Subject: Y/71/20/RES

Engineers Comments Regarding Surface Water Drainage

Reserved Matters Comments

TYPICAL PIPE BEDDING DETAIL:
TYPE 3 (UPVC PIPES)

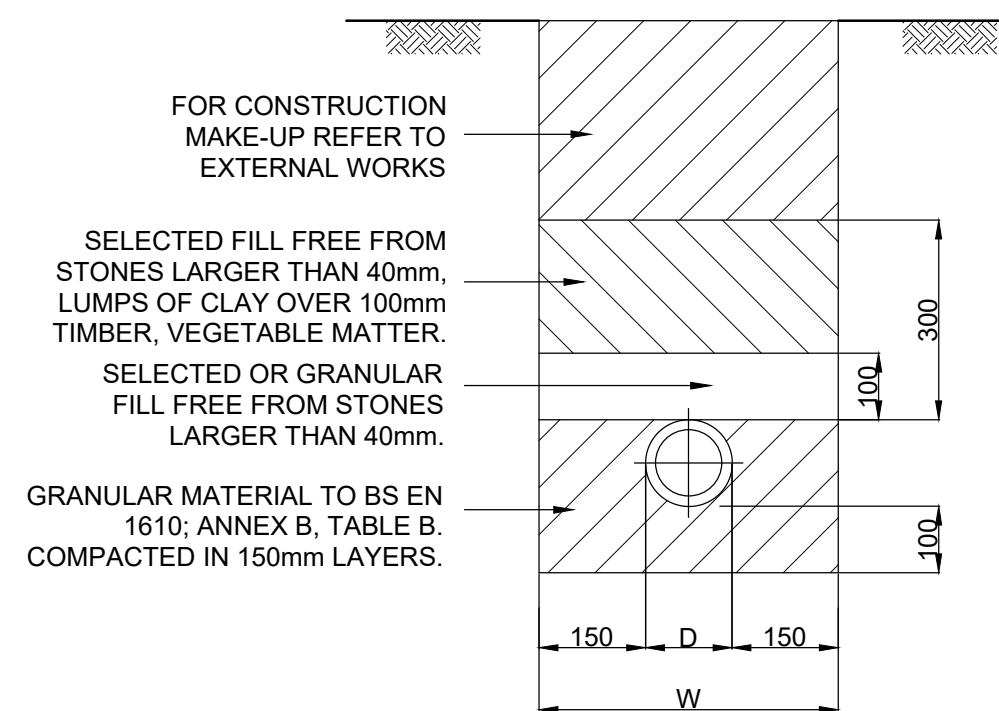
3. Please provide construction detail drawings of pipe bed and surround.
4. Please provide construction detail drawings that clearly correspond to each of the proposed permeable paving types.

INFILTRATION BASIN SECTIONS
38 UNITS

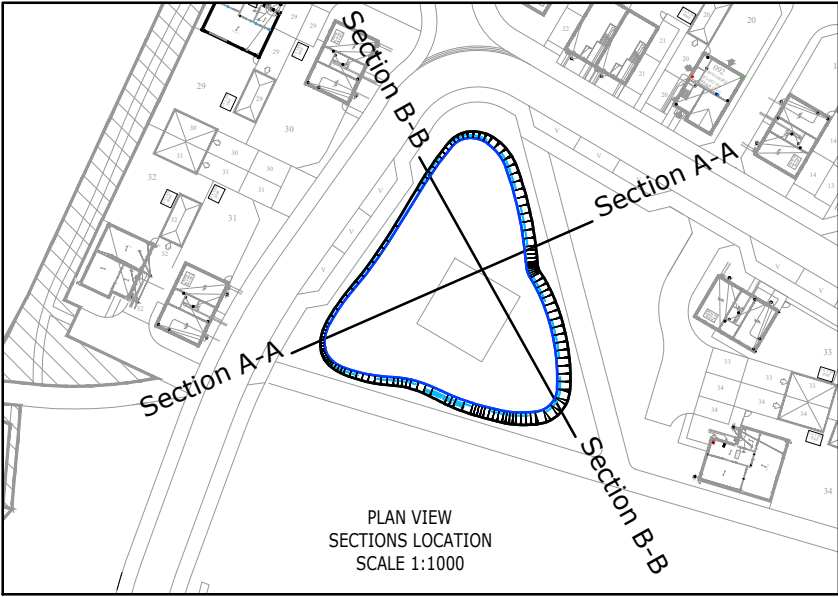
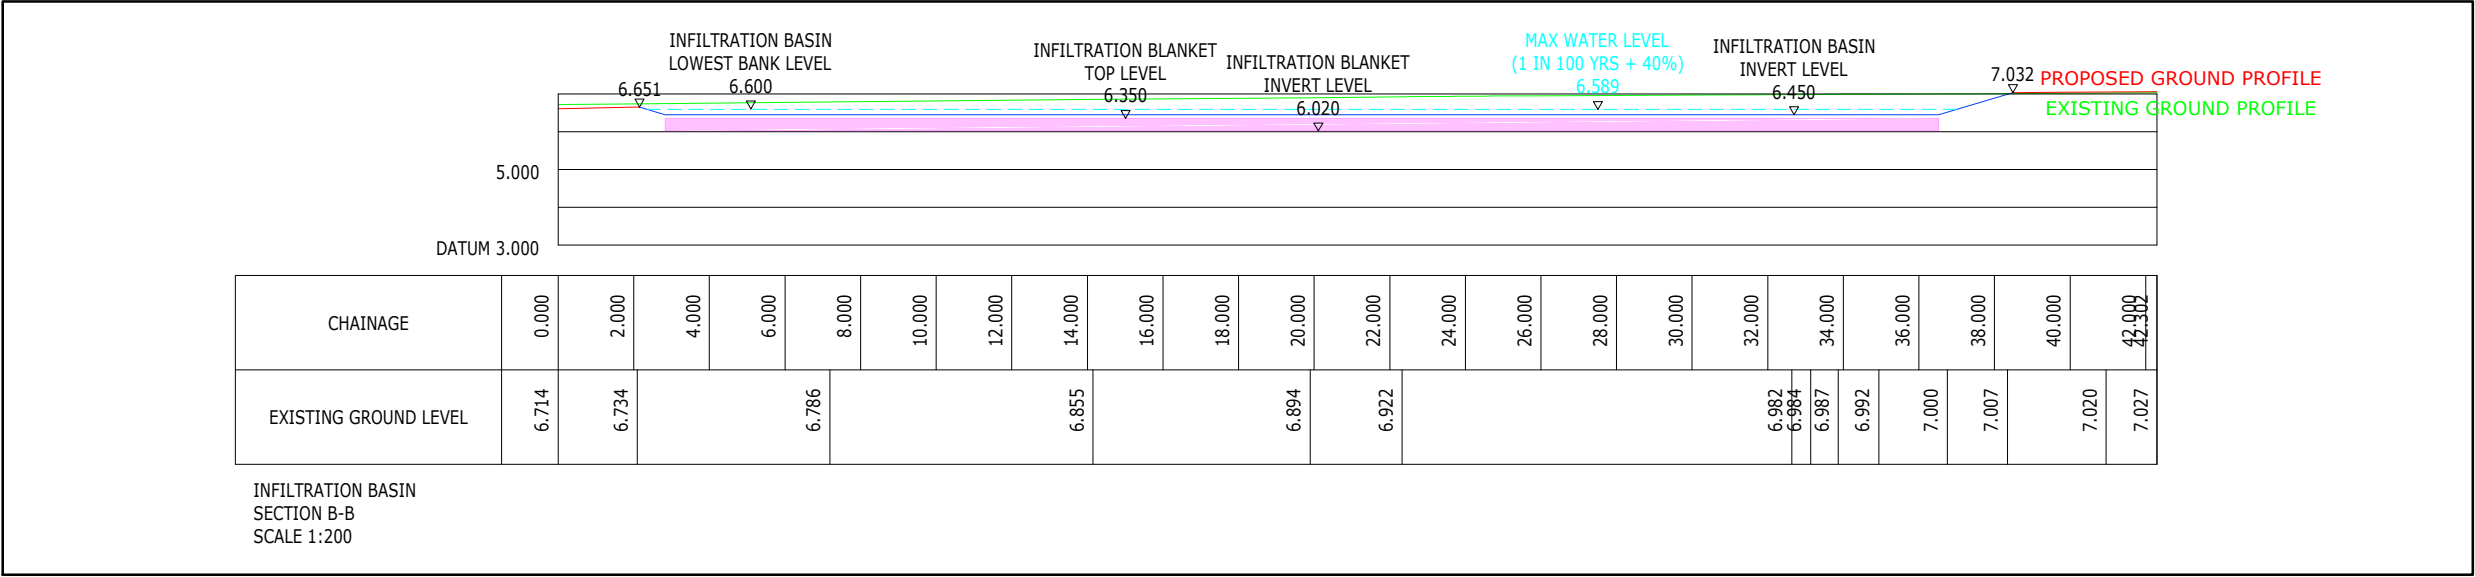
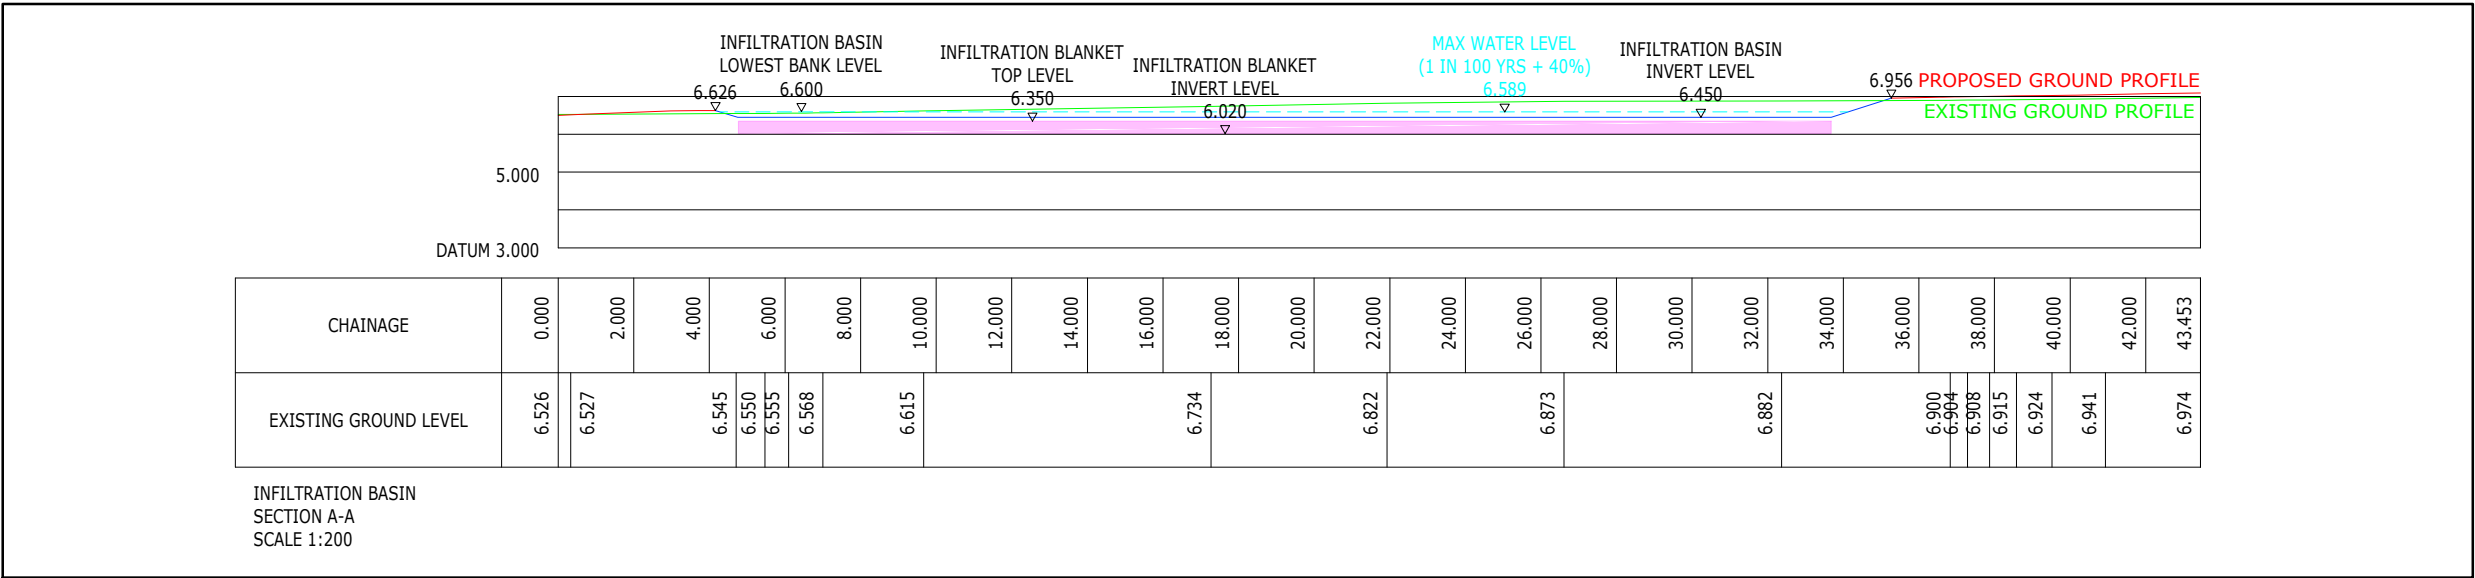
1. There appears to be conflict between the proposed public open space and surface water drainage proposals. There is a shallow infiltration basin proposed within the public open space, a LAP is even proposed within the basin. This is not appropriate. It is stated that water will only emerge on the surface here for events in excess of approximately the 1 in 10 year event, however with climate change and more intense storms it can be anticipated that the basin will have water in more frequently than this.

1. Successful resolution of the above reserved matters points.
2. Please provide two perpendicular site specific cross sections of the proposed infiltration basin. These should show invert level, maximum water level, bank level, construction including connection between sub-base and basin.
